Phone: 0300 123 6780  
Email: [Kathryn.Walsh@lancashire.gov.uk](mailto:Kathryn.Walsh@lancashire.gov.uk)  
Your ref: 3/2025/0285  
Our ref: 3/2025/0285/HDC/KW  
Date: 01 May 2025

**Location:** Parsonage Farm York Road Wilpshire BB1 4AE  
**Proposal:** Reserved Matters: Erection of two-bedroom detached farm workers dwelling 1.5 storey with attached single garage pursuant to Outline application 3/2021/1015.  
**Grid Ref:** 370099 432289

The Local Highway Authority (LHA) are in receipt of an application for the proposed erection of two-bedroom detached farm workers dwelling 1.5 storey with attached single garage pursuant to outline application 3/2021/1015 at Parsonage Farm York Road Wilpshire.

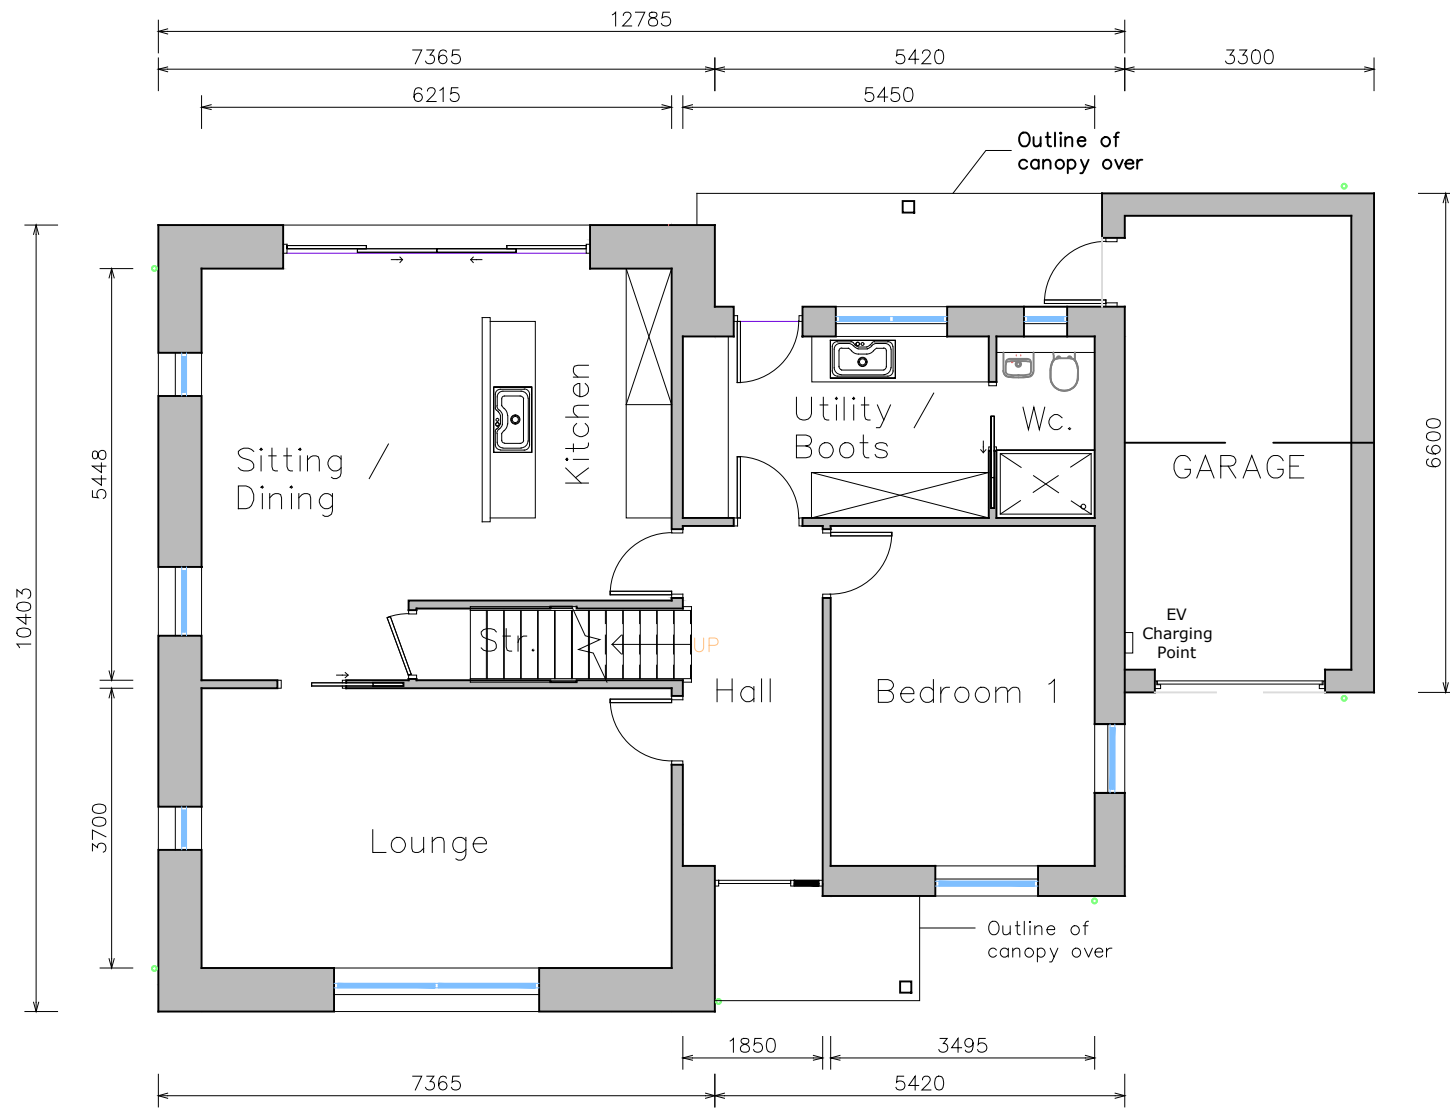
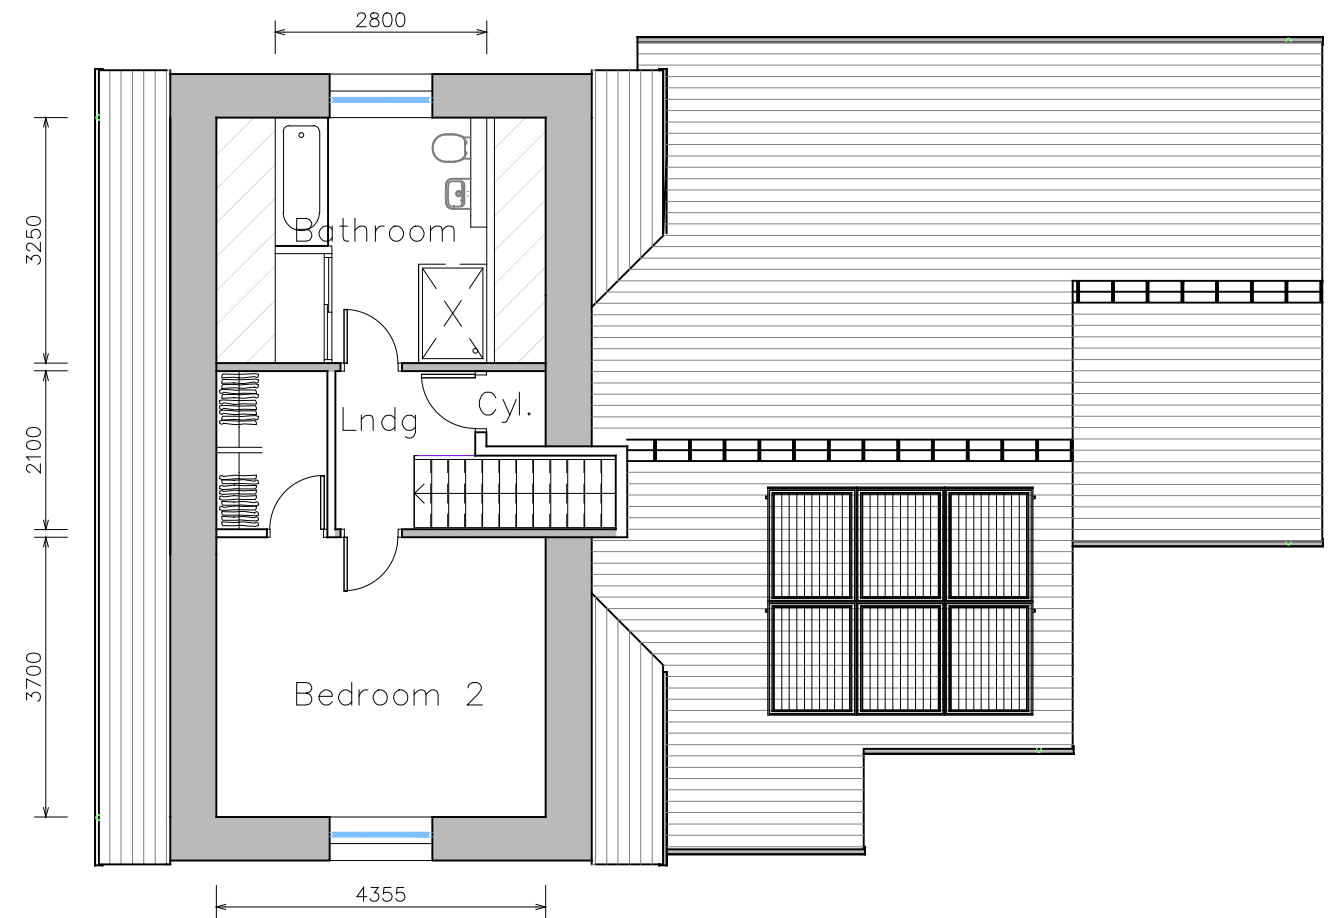
The LHA also reviewed drawing GM-PF-2025(A)-01 and noted that the proposed garage meets the LHA recommended minimum internal dimensions for a single garage size which is 6m in length and 3m wide.
